**KIRKLEES METROPOLITAN COUNCIL
INVESTMENT & REGENERATION SERVICE**

Reference No: 2021/62/90890/E

Site Address: Wilman And Son, 1, Market Place, Batley, WF17 5DA

Description: Alterations to convert estate agent to restaurant/cafe
(Class E) (Listed Building within a Conservation Area)

EXISTING GROUND FLOOR PLAN
SCALE 1:100@A1

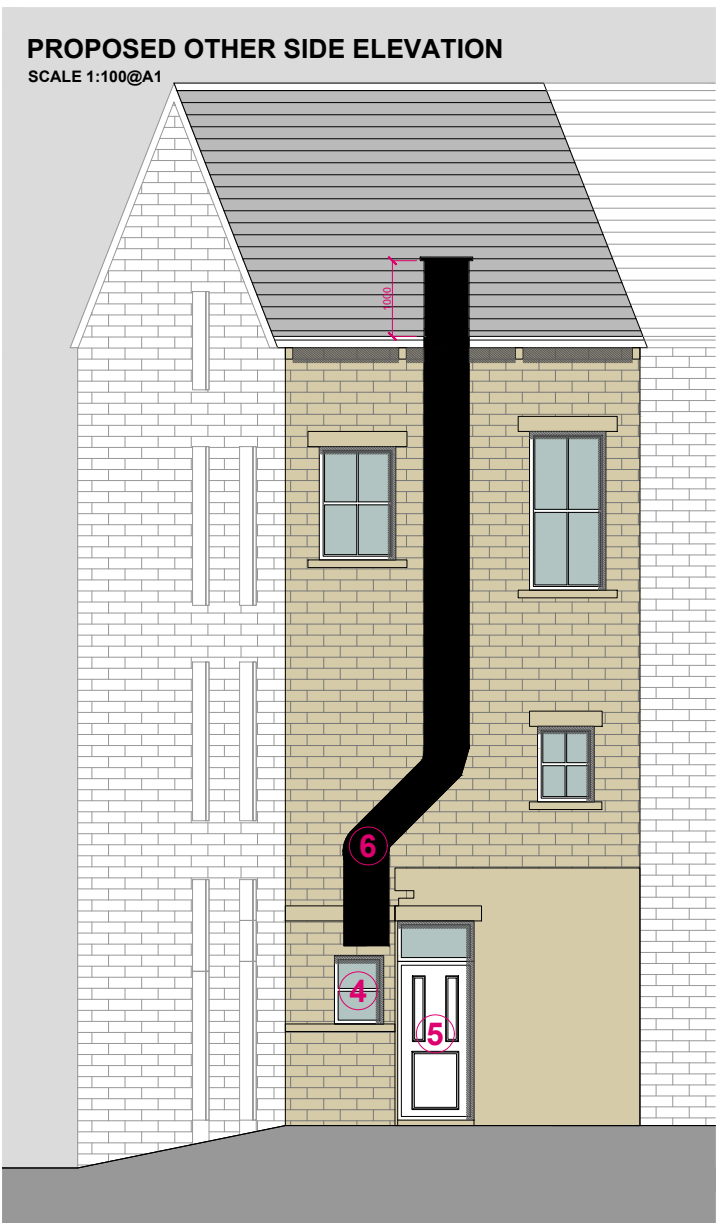
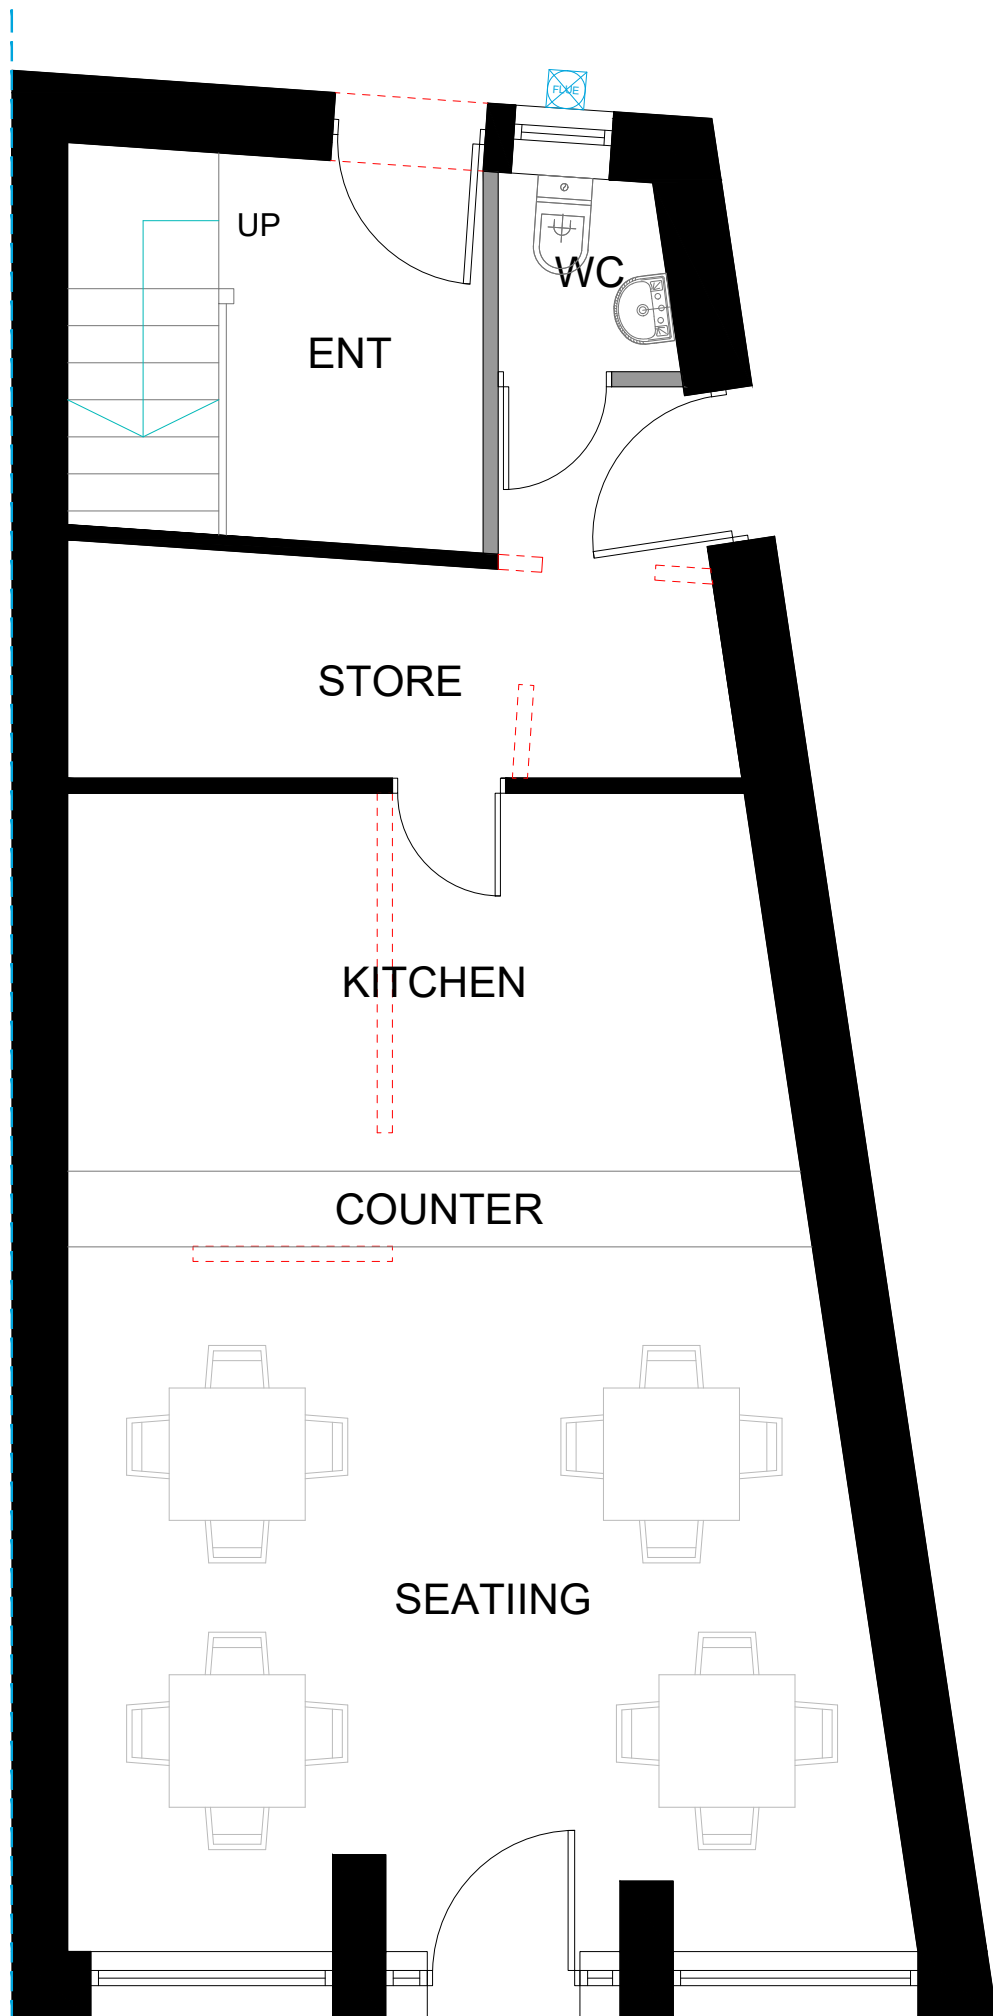
By virtue of part of the application being a change of use, this itself will not materially adversely impact upon the listed building or the Conservation Area. The alterations to the interior and exterior of the building, including stripping out finishes and altering the shop front, are minimal and include the removal of later partitions and minor alterations to areas of low significance and are, therefore, acceptable. The repair of the existing timber shop front is supported, as this will improve the facade, with signage illuminated by grey swan neck light fittings fixed to the timber shop front and not into the masonry.

The rear elevation is only visible from Back Providence Street and has relatively low significance, therefore the proposed interventions to the rear elevation are acceptable. The harm caused by the installation of a flue is mitigated by finishing it in black and fixing it to the rear elevation, and the public benefit of repairing and refurbishing the shop front and bringing this vacant building into use is considered to outweigh this slight harm.

Subject to a condition requiring all flue brackets to be fixed into mortar joints and not into the masonry, the principle of development to a listed building in the Conservation Area is considered acceptable, as the proposal complies with policies LP24 and LP35 of the KLP and Chapter 16 of the NPPF.

7. Notwithstanding the plans hereby approved, all flue brackets shall be fixed into mortar joints and not into the masonry on the building.
